Permit Number: 070245

has permission to New signage - Install one (1) building sign and one (1) awning signage

AT 320 FORE ST - Unit #1 Gold St.

Drawing file: 1. Original Plans / Sketch Plan.pdf

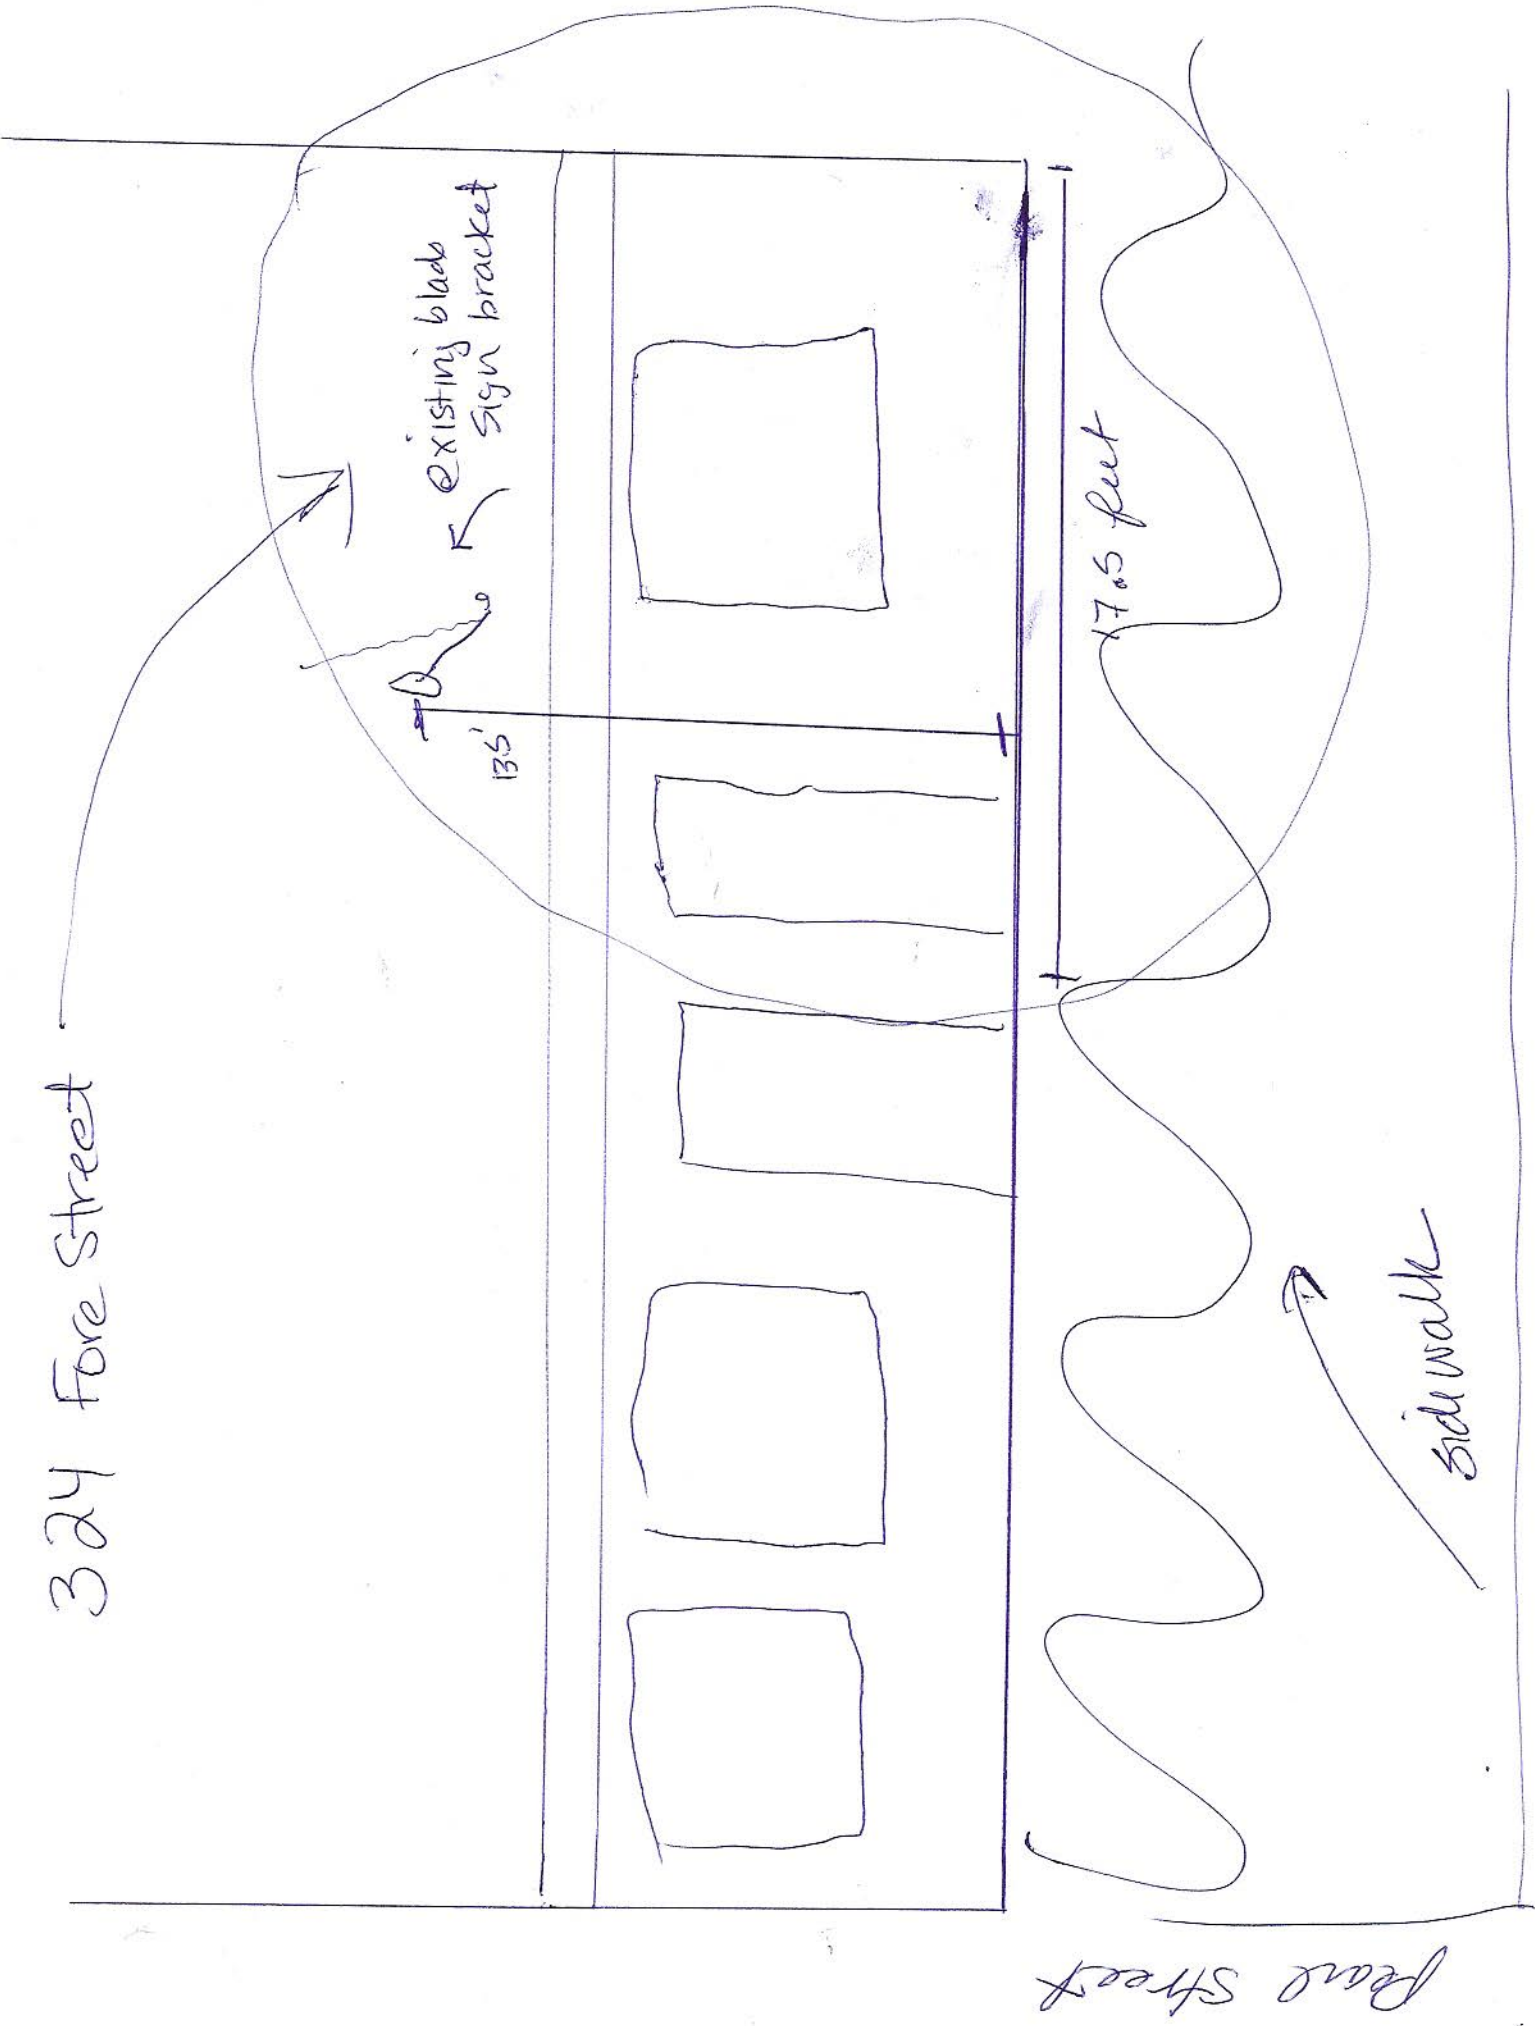
1) \* Corner sign to be positioned as shown in rendering dated 4/12/07 (attached).

\* HP Staff to be contacted prior to scheduled installation to coordinate final placement of corner sign in relation to existing sign. Staff will meet on site to oversee placement.

\* Awning to match the physical characteristics and alignment of the existing awning at One Gold Street.
